A38 DERBY JUNCTIONS SCHEME—LITTLE EATON JUNCTION.
APPLICATION FOR DEVELOPMENT CONSENT ORDER

ANSWERS BY BREADSALL PARISH COUNCIL TO THE EXAMINING
AUTHORITY'S FIRST WRITTEN QUESTIONS

Drawing Title  
FIGURE 2.7  
LITTLE EATON JUNCTION  
GENERAL ARRANGEMENT

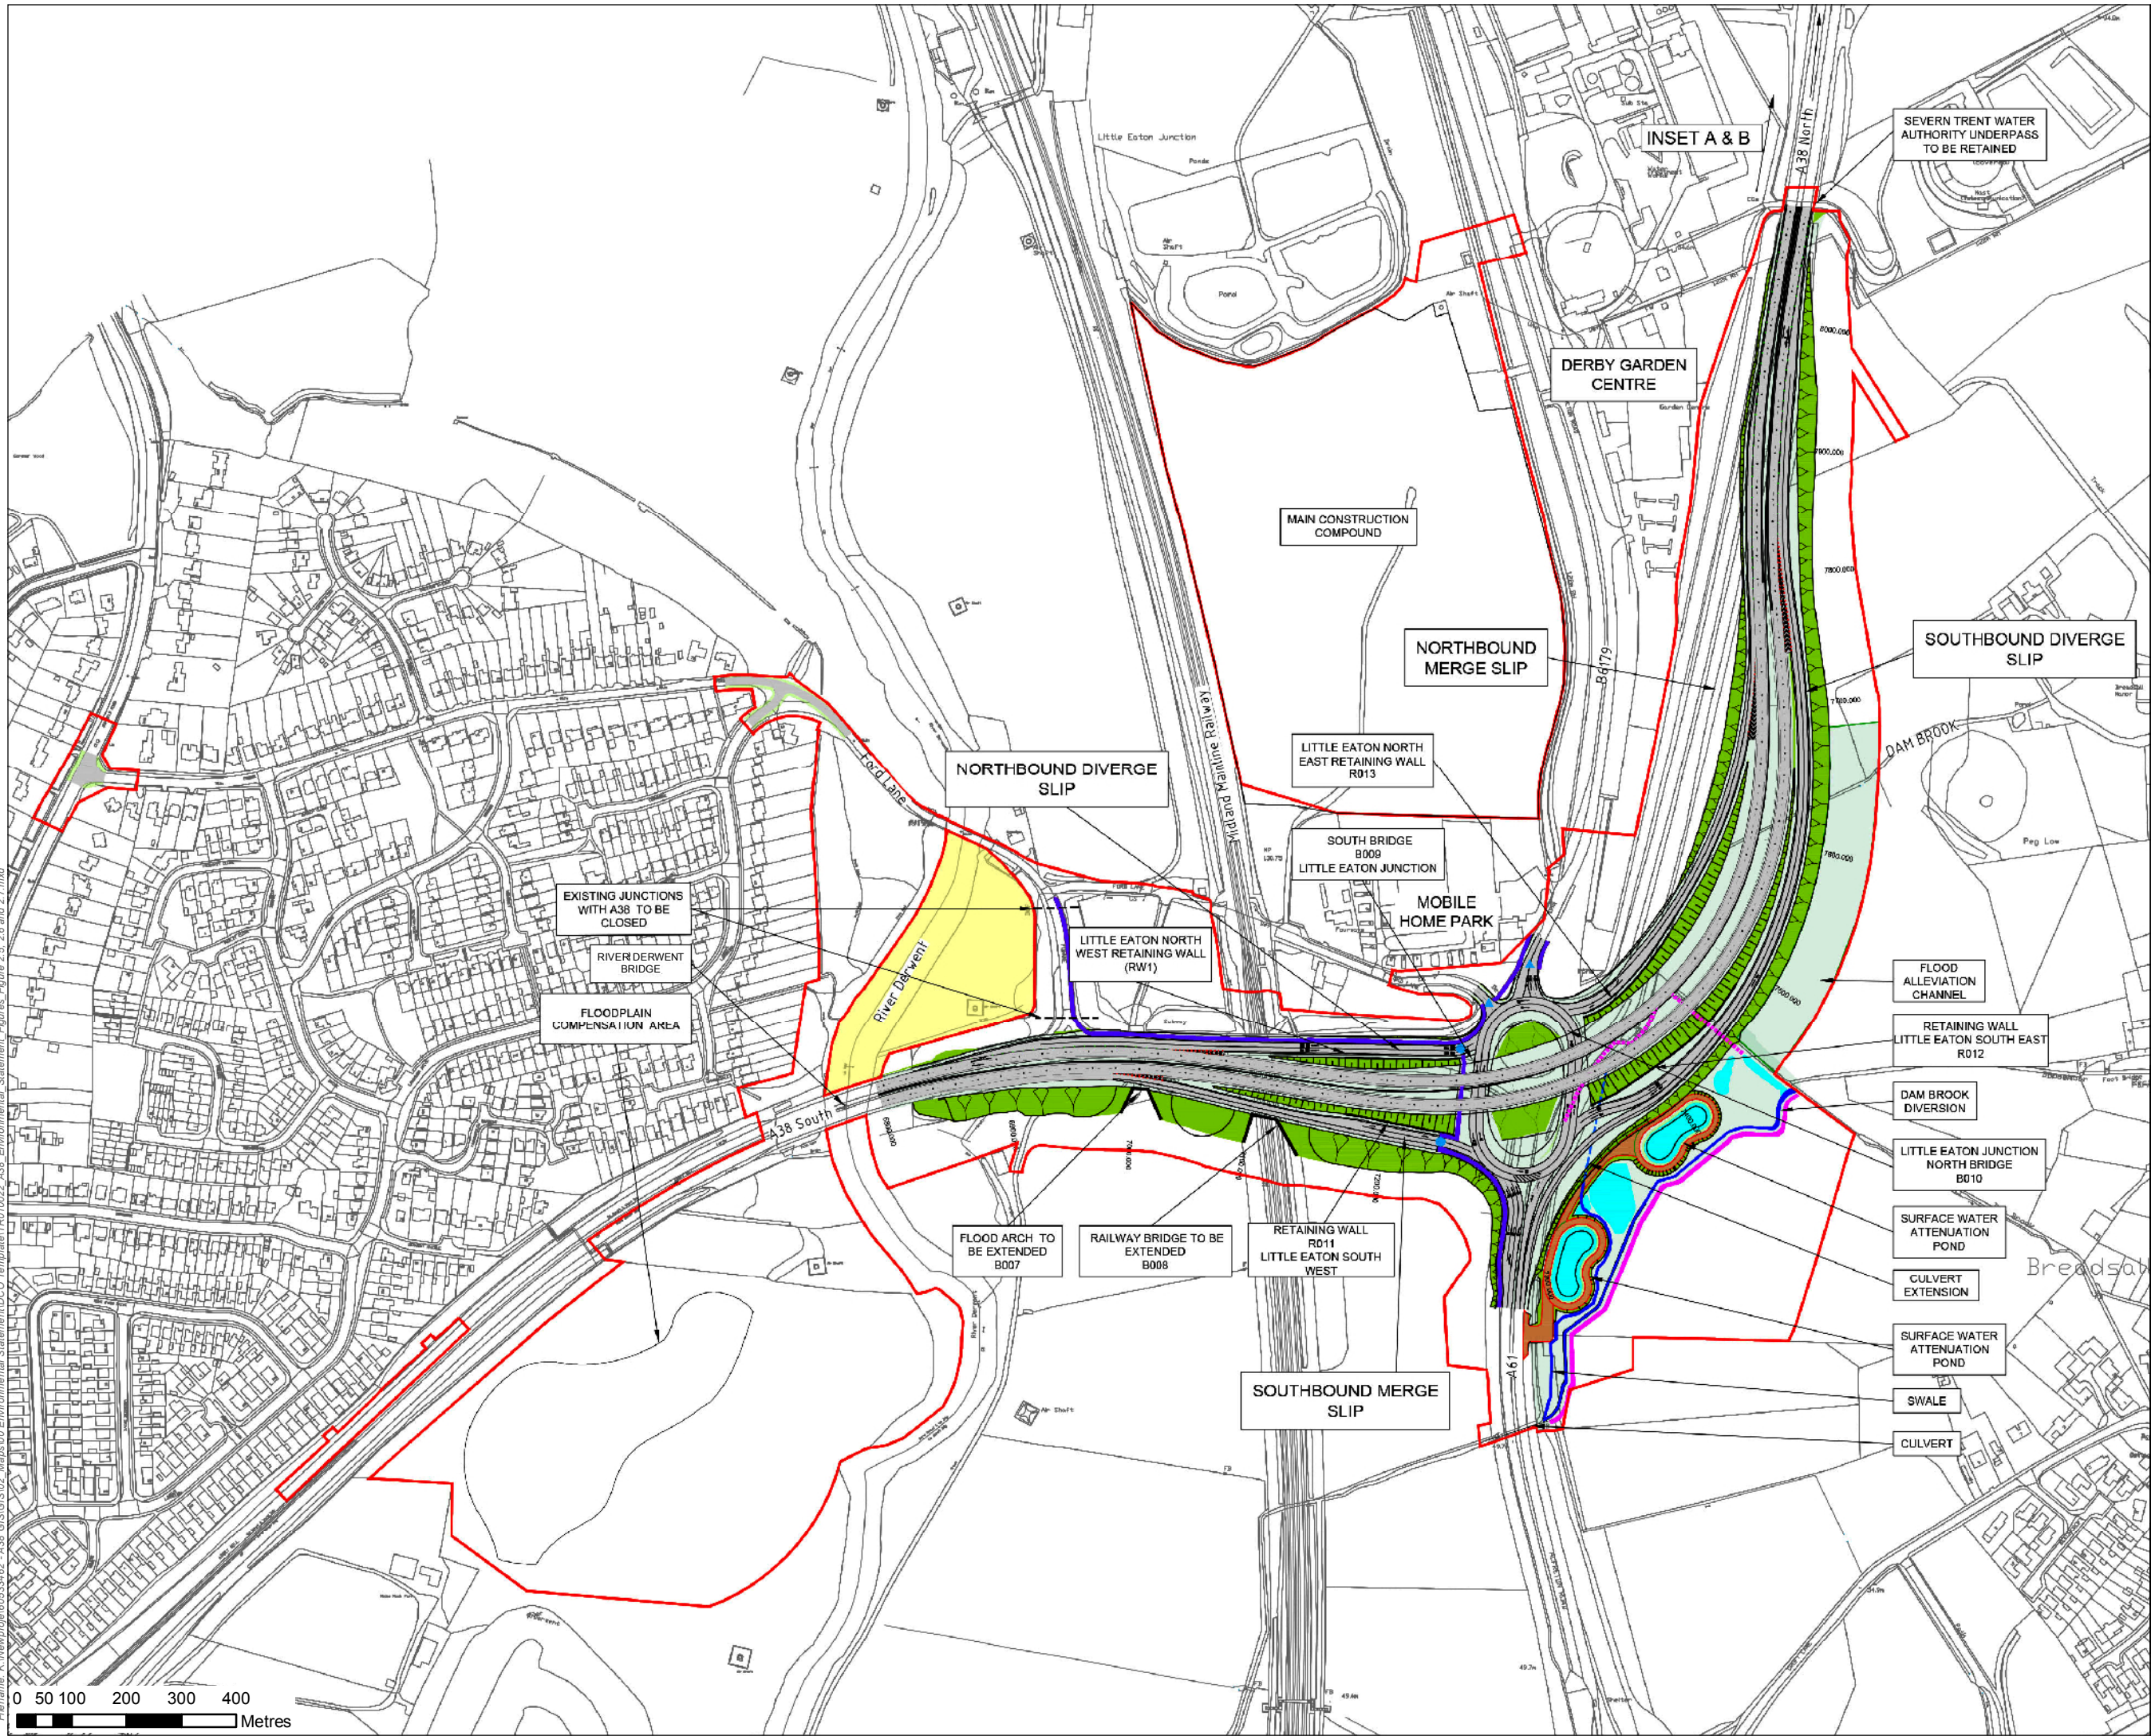
4.37 The Parish Council supports a 50mph speed limit at the Little Eaton Junction for three reasons

- This should reduce noise levels and air pollution
- This gives more freedom in the design of the carriageway, in particular permitting a tighter radius. This in turn may be relevant to the Parish Council's objections to the choice of the preferred route. (See answer to 2.6 above).
- It is understood that even the current design involves an advisory 50mph limit.

10.13 This footpath is the only direct route from Breadsall to the north side of the Little Eaton Junction and has a length of a little under half mile. The proposed diversion appears to involve a total detour in the order of one mile which would triple the existing distance. This is clearly unacceptable. More detailed comments are given in Part 2 of the Parish Council's written representations.
